Whitehead & Associates

Ref: 1912 RTC 220518sd

Re: Wastewater Assessment for North Byron Parklands

1. Introduction

Figure 20 | Proposed Wastewater Treatment System

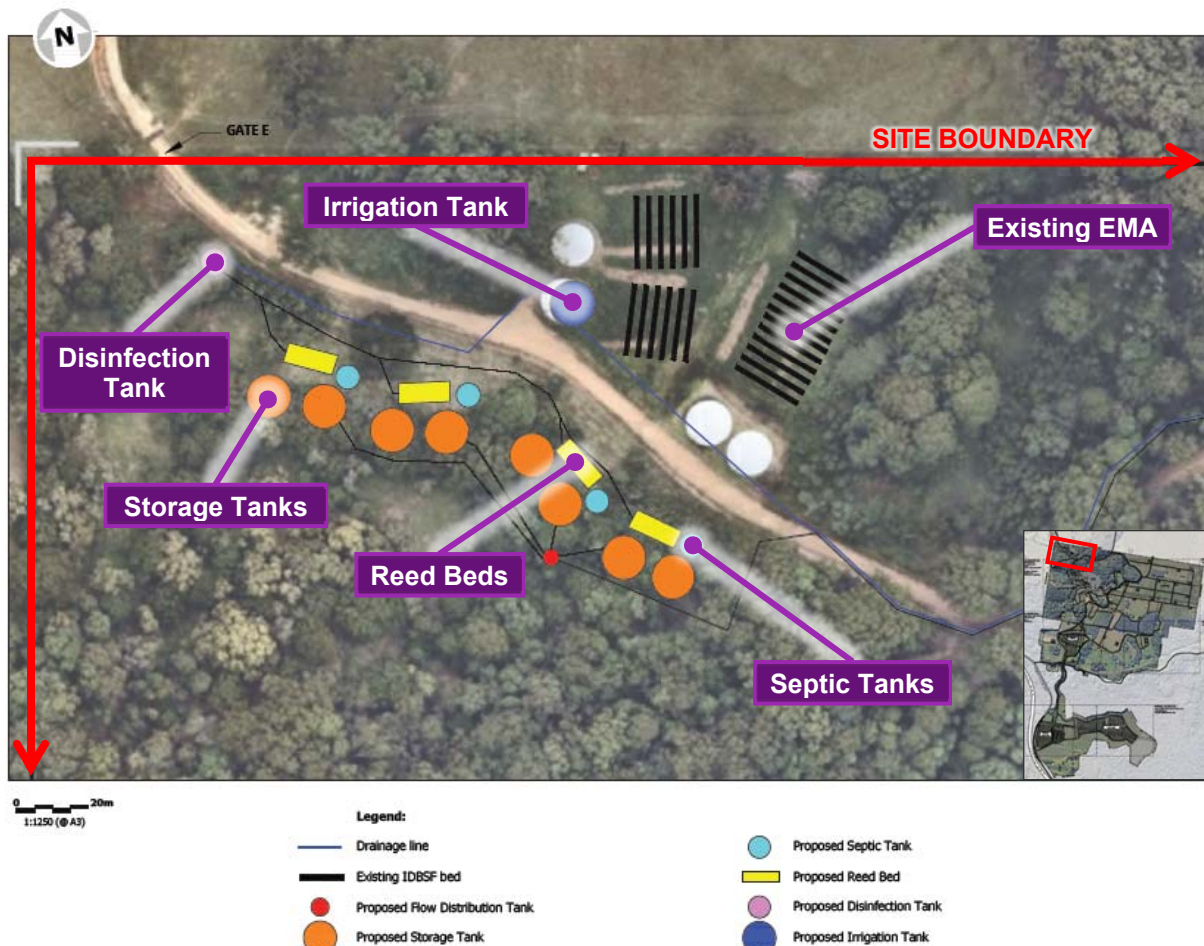
Item	GHD Comment	Response
1G	The irrigation of treated wastewater on a flood plain area is considered a contamination risk on and off-site.	<p>The NSW EPA's <i>Use of Effluent by Irrigation</i> (2004) guidelines state that employing floodplain areas can be acceptable for effluent irrigation (S2.8) subject to appropriate engineering controls.</p> <p>W&A concur that irrigation onto a floodplain has management issues, but that floodplains across NSW and locally provide productive spaces used by various agricultural activities such as sugar cane farming and dairying. These activities operate throughout the year, and manage wastewater application (particularly dairies) through flood events.</p> <p>The OSMS design by W&A allows for a three day withholding wet weather storage and an above floodplain emergency land application area, plus a pre-event withholding period of up to 4 weeks per event, which can be utilised in cases of direct flood situations or to catch up on the irrigation cycle following these events. The land application area is based on a water balance that accounts for higher rainfall periods (i.e. a lower land application rate to account for increased soil moisture), and use of vegetation uptake zones adjacent to drains.</p> <p>The irrigation area required for hydraulic loading based on rainfall and evaporation effects is only ~17,000m², much less than the proposed ~36,000m² footprint. This results in the actual irrigation rate being much lower than the allowable required to limit deep percolation to groundwater and surface runoff. The larger footprint was based on nutrient balancing requirements to ensure net export of nitrogen and phosphorus are within allowable cumulative impacts.</p> <p>The original WWMP prepared by Gilbert & Sutherland in 2010 that was approved for the property, also allowed for land application onto the floodplain, and modelled the land application using alternative irrigation models to those by W&A. That assessment also confirmed no significant cumulative impact to surface or groundwaters.</p>

Item	GHD Comment	Response
5G	Areas designated for treated wastewater sub-surface discharge, irrigation and compost burial are not proposed to be equipped with infrastructure to control stormwater run-off in case of contamination.	<p>The wastewater assessment notes that further detailed engineering design for the sewer reticulation and treatment system would be undertaken as part of the treatment system plans and s68 application. The EIS includes commitments to preparing a detailed Wastewater Management Plan, along with Stormwater Management Plans for applicable infrastructure. Bunding and stormwater control would be detailed in these detailed plans.</p> <p>It is reasonable given the scale of the treatment area to provide spill and run-on and runoff control measures at the main treatment plant site.</p> <p>Compost is required to be buried at 100mm below the surface, and given the ability to choose the day of burial, non-raining conditions can be chosen. As such stormwater diversion is not considered applicable for small compost (tree planting and maintenance) locations. Compost management and any stormwater management measures would be detailed in the Wastewater Management Plan.</p> <p>Stormwater run-on berms are typically required upslope of effluent land application areas. At the proposed irrigation areas of NBP these are not considered to be practical or warranted given the low almost flat ground surface. More important is run-off control. Given the almost flat ground surface, run-off is very low naturally but has been accelerated by the historical excavation of a drain network through the site during previous sugarcane farming. These drains form an important part of the modified landscape which W&A considered in the WWA. Installation of downslope run-off berms were considered but are not practical as they would limit draining of the ground surface and cause pooling of water. The WWA recommended planting of vetiver grass vegetation strips along all drains. These would form both a hydraulic and nutrient barrier, as a 1m² planting of vetiver can utilise up to 6L of water/wastewater per day.</p> <p>The presence of vetiver grass strips for water and nutrient uptakes were not considered in the wastewater modelling and would provide additional sinks beyond that required.</p>

Item	GHD Comment	Response
	 <p style="text-align: center;">Storage balance chart as presented in WWA.</p>	
9G	The stated treated water quality for irrigation is considered not to be achievable especially on days 5- 7 of a large event.	See response to Comment 8G above, Given the design of the treatment train, a maximum of 35kL/day would be treated through the primary system and reed bed polishing. Quality would be maintained, as demonstrated through limiting maximum flow rates through the reed beds and thereby maintaining the design hydraulic residence time of the wastewater within the beds.
10G	The proposed arrangement allows only for expected year- round average daily flow of 35 kL/day treated wastewater which would theoretically enable two days storage (outside events) in the septic tank and loading of	<p>The reed bed sizing in the WWA was based on the calculation sheets prepared by W&A utilising largest area requirements based on BOD, nitrogen, suspended solids and faecal coliforms inputs.</p> <p>The BOD calculations were derived from published work by Headley & Davison in 2003¹.</p>

Item	GHD Comment	Response
	some 1-200 kg BOD/ha/d, on the reed beds which may be suitable. However, BOD monitoring results would need to be confirmed from the proponent and further justification of demand and discharge volumes, before we would be able to regard the acceptability of the system.	<p>The hydraulic and nutrient balance model utilised for the irrigation area also provides a reed bed sizing calculation separate to that utilised by W&A.</p> <p>W&A calculated a reed bed required area of 400m², whilst the alternative model approved by Byron Shire Council calculated an area required of 244m². W&A conservatively adopted the larger footprint, and there is potentially capacity within the reed beds to treat larger than design hydraulic flows.</p> <p>Given the capped flows, disinfection ability would not be affected.</p>
11G	The proposed disposal of treated wastewater via irrigation on a flood prone area is considered a high risk.	See responses to comments 1G and 5G above. The risks are able to be effectively managed in accordance with the EPA's effluent irrigation guidelines and applicable standards through engineering controls, conservative modelling of areas required, timing, withholding ability, disinfection and vegetative uptake zones.

Figure 21 | Proposed location of the North-Eastern Effluent Management Area

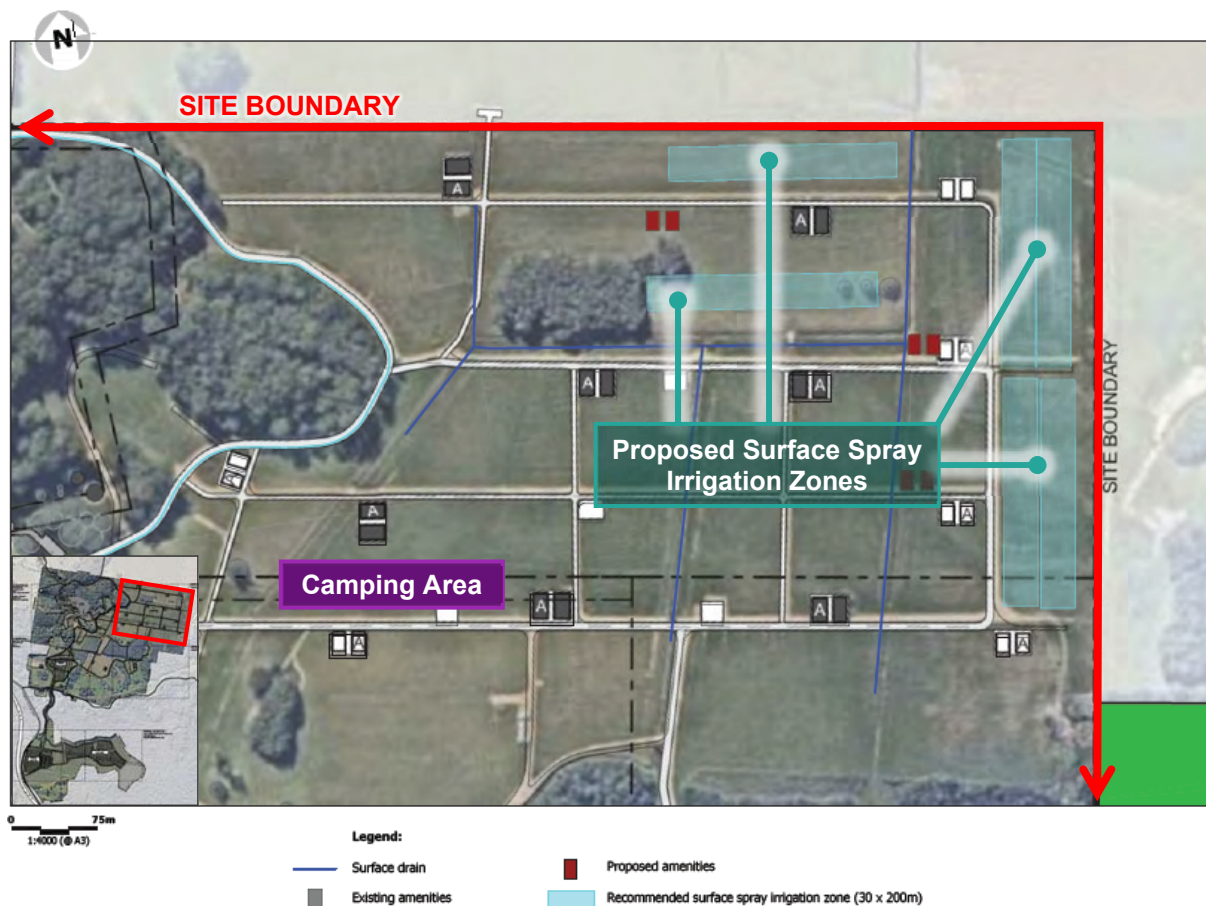
Item	BSC Comments	Response
2B	<p>A review of the Tweed Byron Flood model has identified that the site of EMA 2 is located below the 1:5; 1:20 and 1:100 flood level. The use of flood prone area for effluent dispersal/ disposal is not acceptable, having regards to the potential impacts of receiving waters within both the northern end of the Brunswick River Catchment and the southern end of the Crabbes Creek/ Mooball Creek Catchment which flows northwards into Tweed Shire.</p>	<p>This issue was also raised by GHD and responded to by W&A in item 1G.</p> <p>The NSW EPA's <i>Use of Effluent by Irrigation</i> (2004) guidelines state that use of floodplain areas can be acceptable for effluent irrigation (S2.8) subject to appropriate engineering controls.</p> <p>W&A acknowledges that treated effluent application on land below the 1in5 flood level poses a higher risk than on land below the 1in20 flood level, and on land below the 1in100 flood level. These risks are usually assessed for domestic situations where wastewater in = effluent out 365 days of the year.</p> <p>The risks for NBP are much lower given the controlled release of treated effluent. The residual risks have been mitigated by engineering the treatment system and land application area, and irrigation methodology, including conservative modelling of area requirements (i.e. low application rate), storage and withholding capacity, alternative EMA that is flood free, buffer zones and vegetative uptake strips along drains. As such, irrigation during flooding will not be required, and if excessive rainfall occurs on a day of irrigation prior to cessation, the risks of runoff have been reduced.</p>
